KIRKLEES METROPOLITAN COUNCIL INVESTMENT & REGENERATION SERVICE

Reference No:	2026/62/90870/E
Site Address:	882, Bradford Road, Birkenshaw, BD11 2AT
Description:	Erection of side extension for entrance to salon
Recommending Officer:	Faiza Bano

HOUSEHOLDER DELEGATED REPORT

proposed ground floor and
entrance elevation

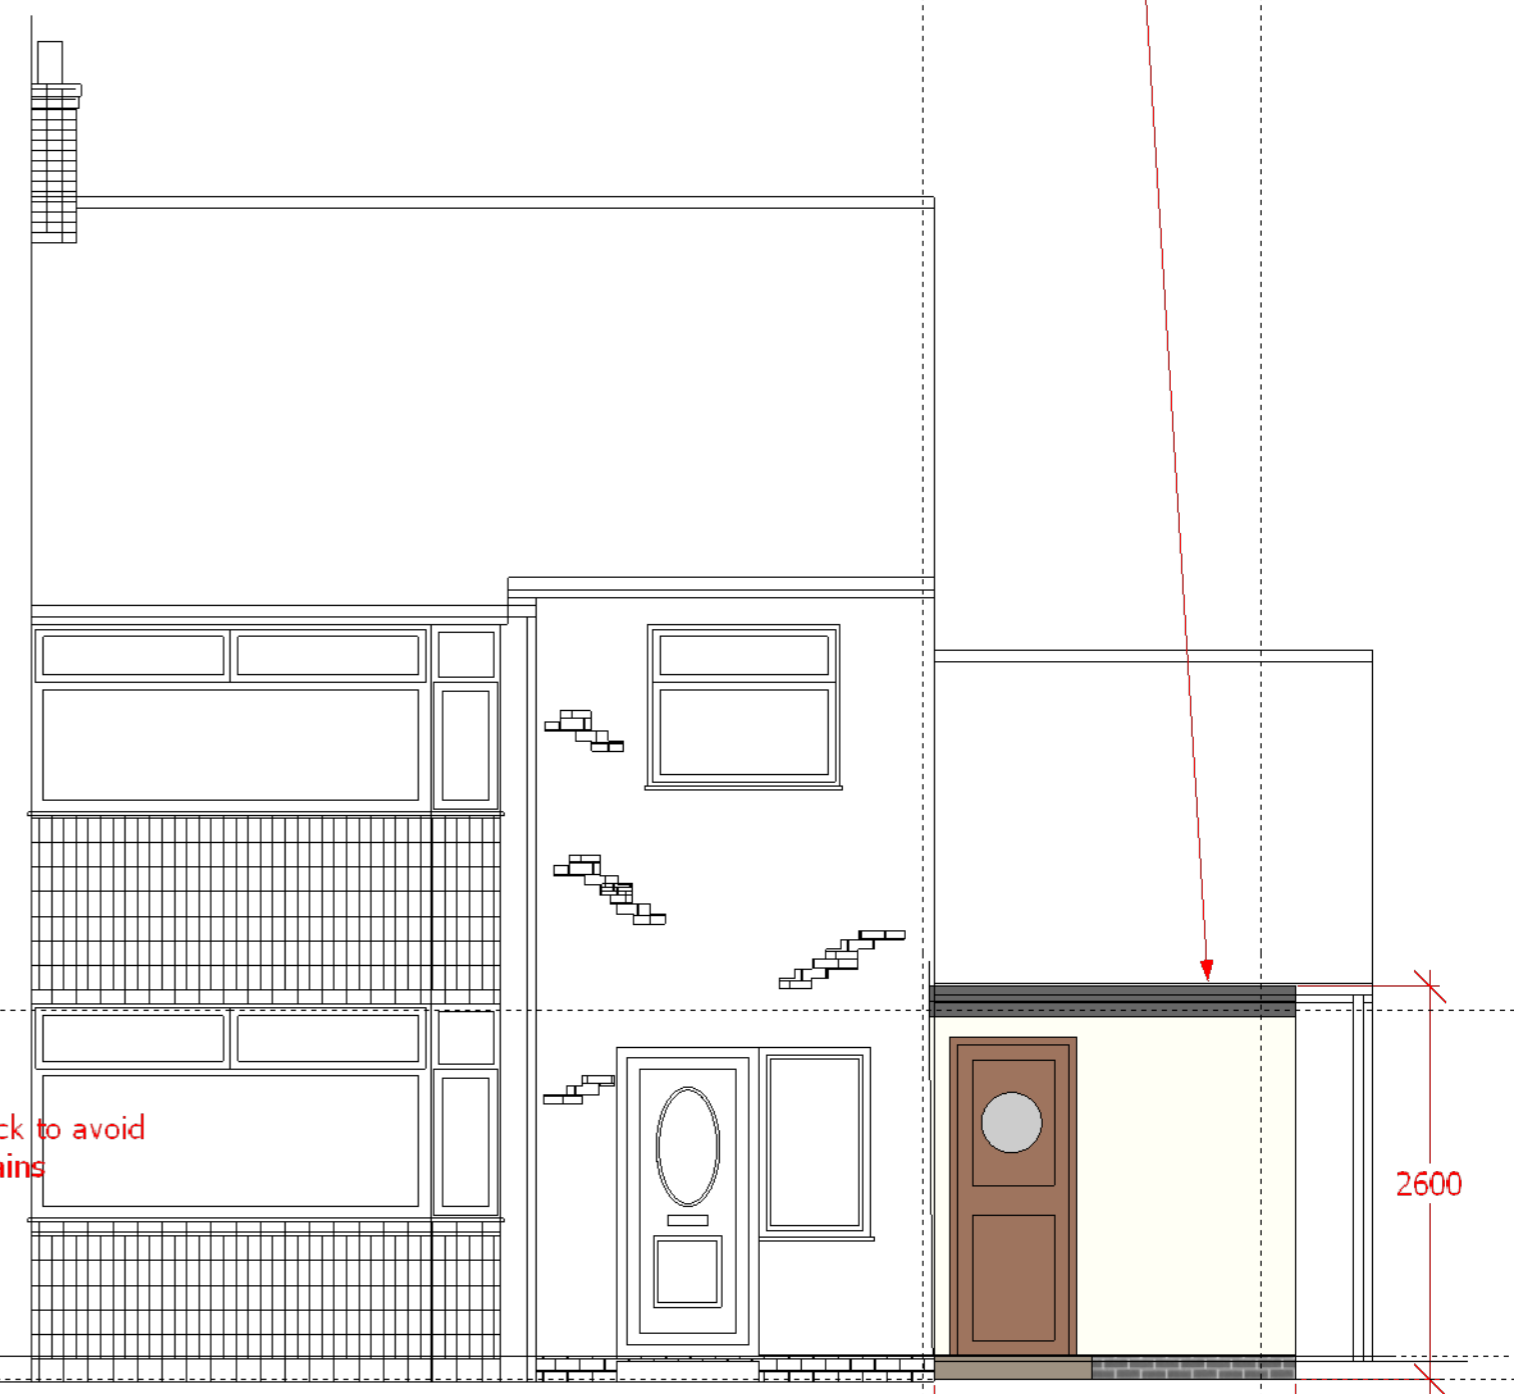
The proposed development includes a single-storey side extension, positioned to the front of the existing salon. The extension would align flush with the existing salon structure.

It would project approximately 2.4 metres from the side elevation and spans a width of 2.7m. The design incorporates a flat roof with an overall height of 2.6 metres.

The extension is intended to provide a lobby area for the existing salon. It is proposed that materials will be used to match those of the existing dwelling, ensuring a harmonious and consistent appearance.

Single storey side extensions should:	<u>Yes - COMPLY</u>	<u>No - JUSTIFY</u>
not extend more than two thirds of the width of the original house	Yes – it would comply with this, it would be less than two thirds of the width of the original house.	
not exceed a height of 4 metres	Yes – the overall height of the extension is 2.6 metres.	
be set back at least 500mm from the original building line to allow for a visual break	Yes – it would comply with this.
